2.2 Consented Scheme Comparison Proposed Scheme - Second Floor

2 Bay F - Plan  
1:50

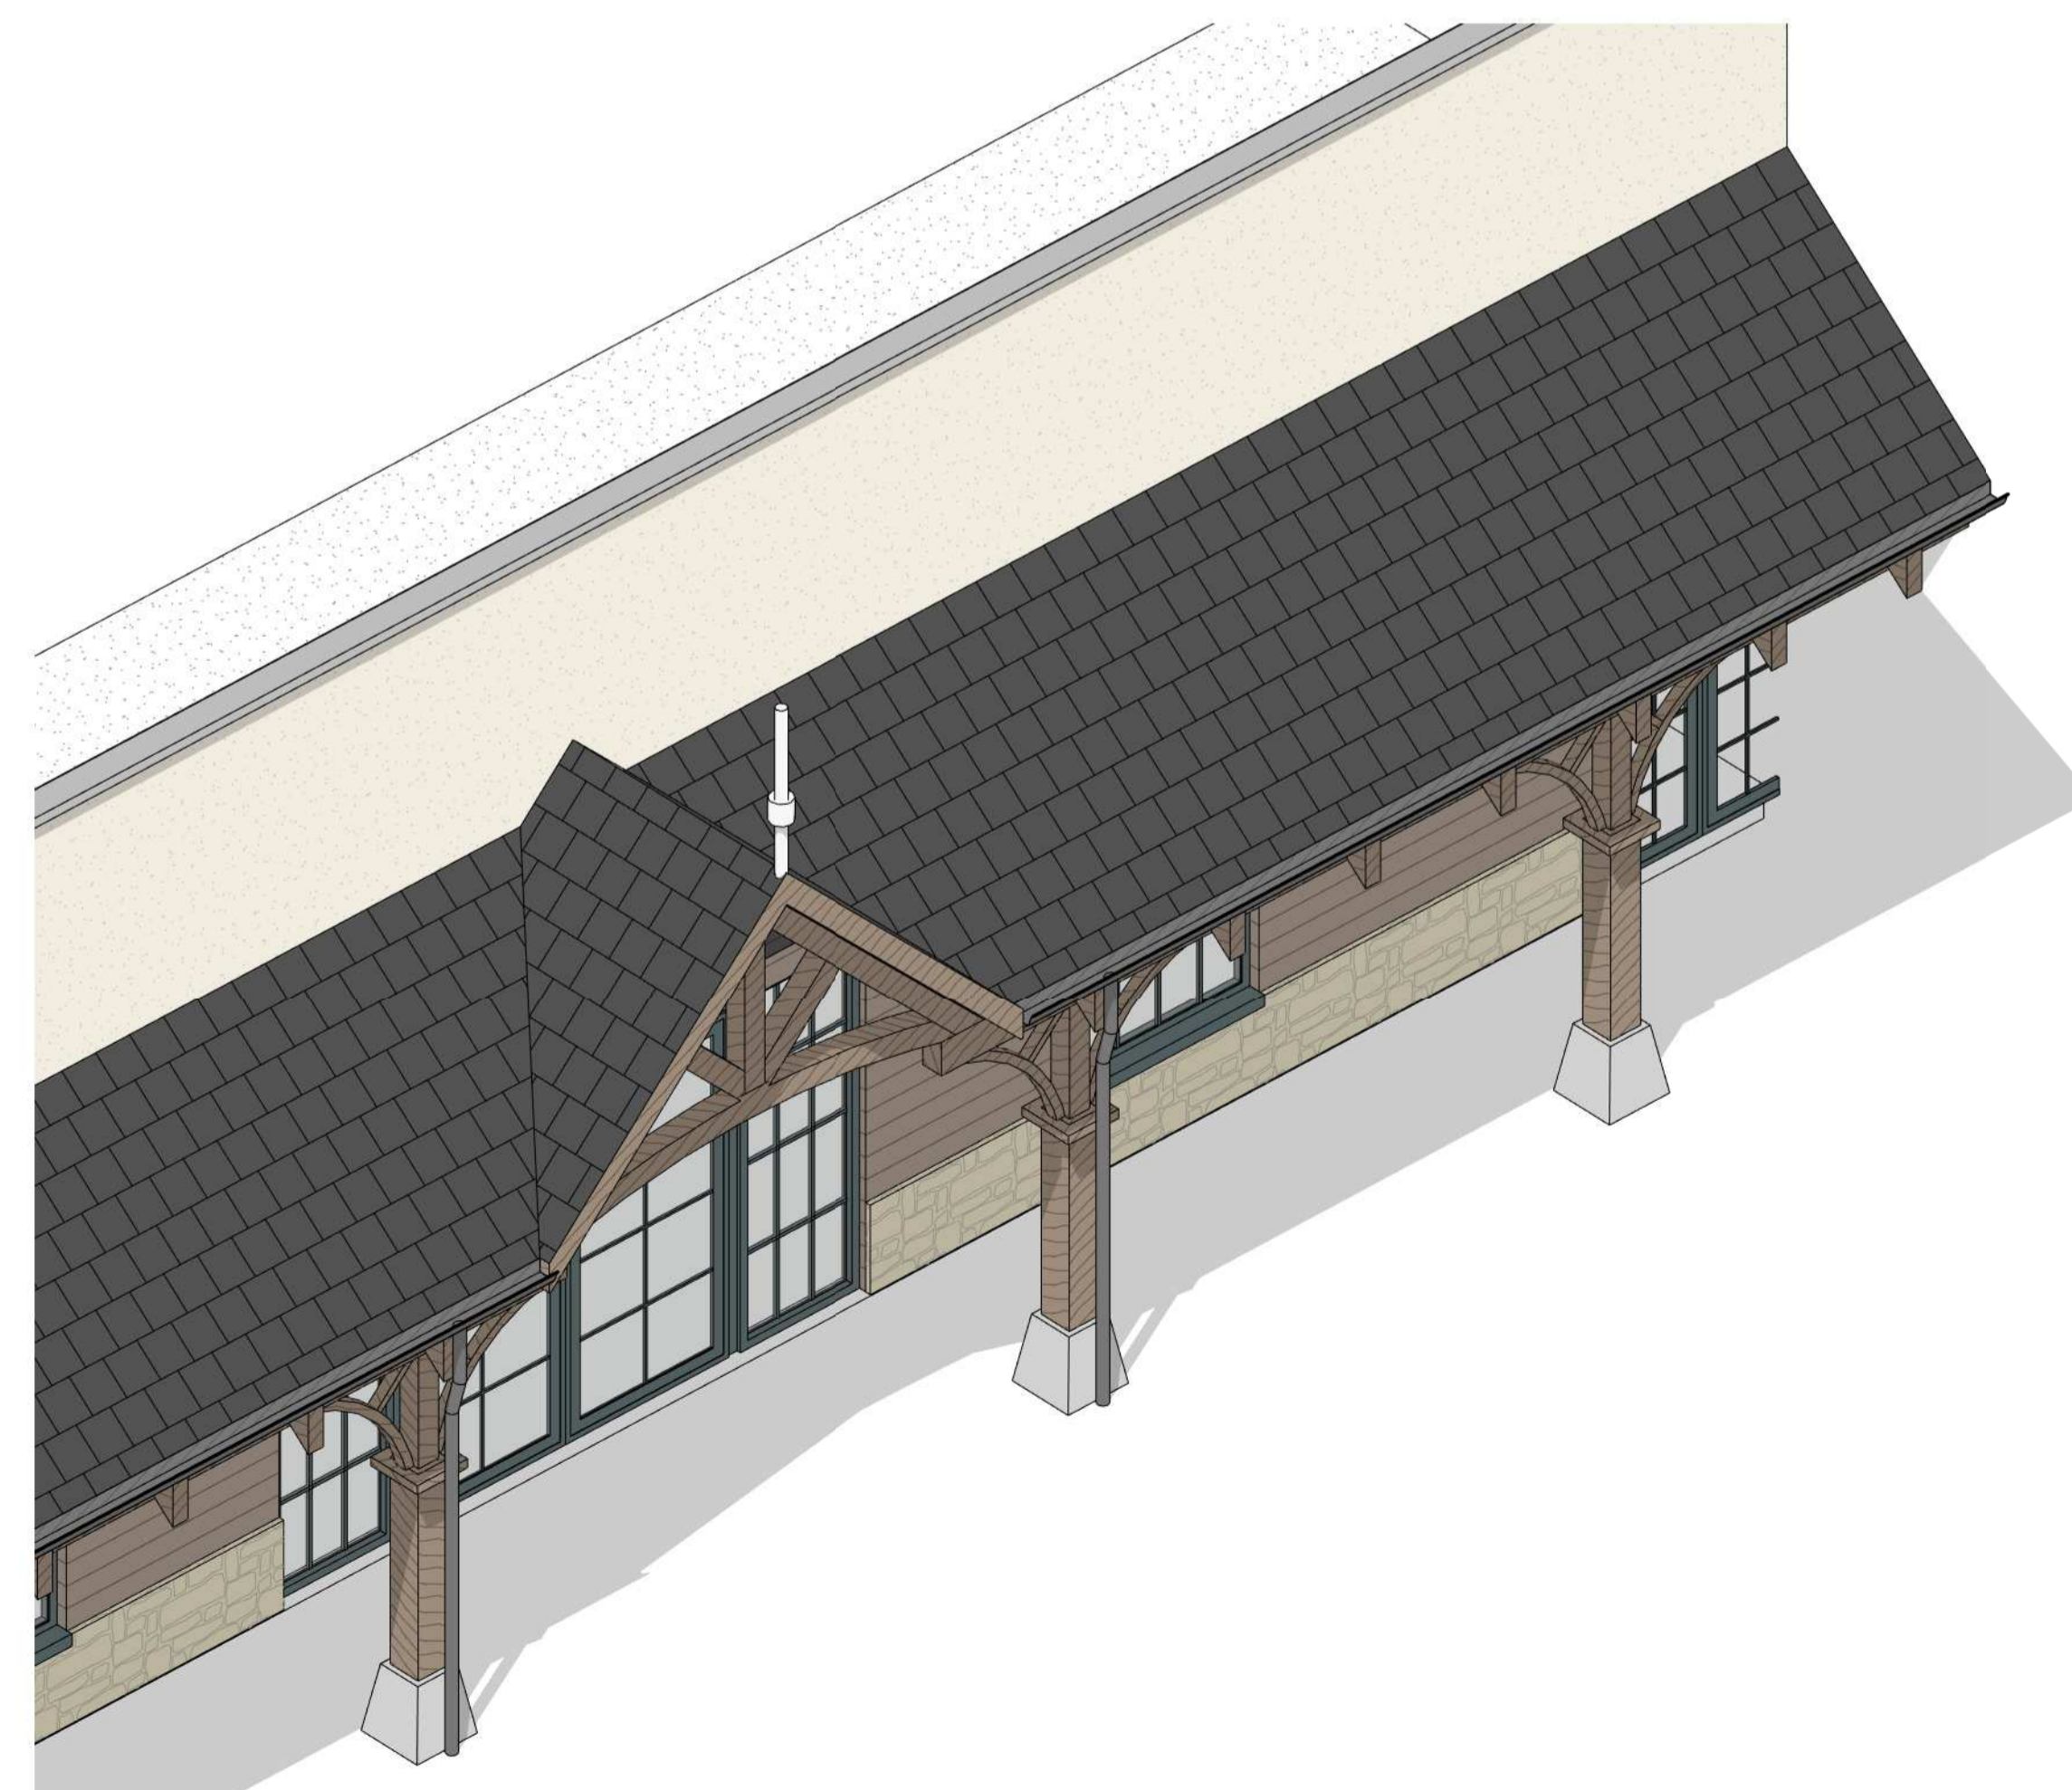
- 1. Re-configuration of the conference centre massing, facade design and internal layout. The overall reduction in the area of the FEC, Conference Centre and main BoH is approximately 1% from consented scheme.
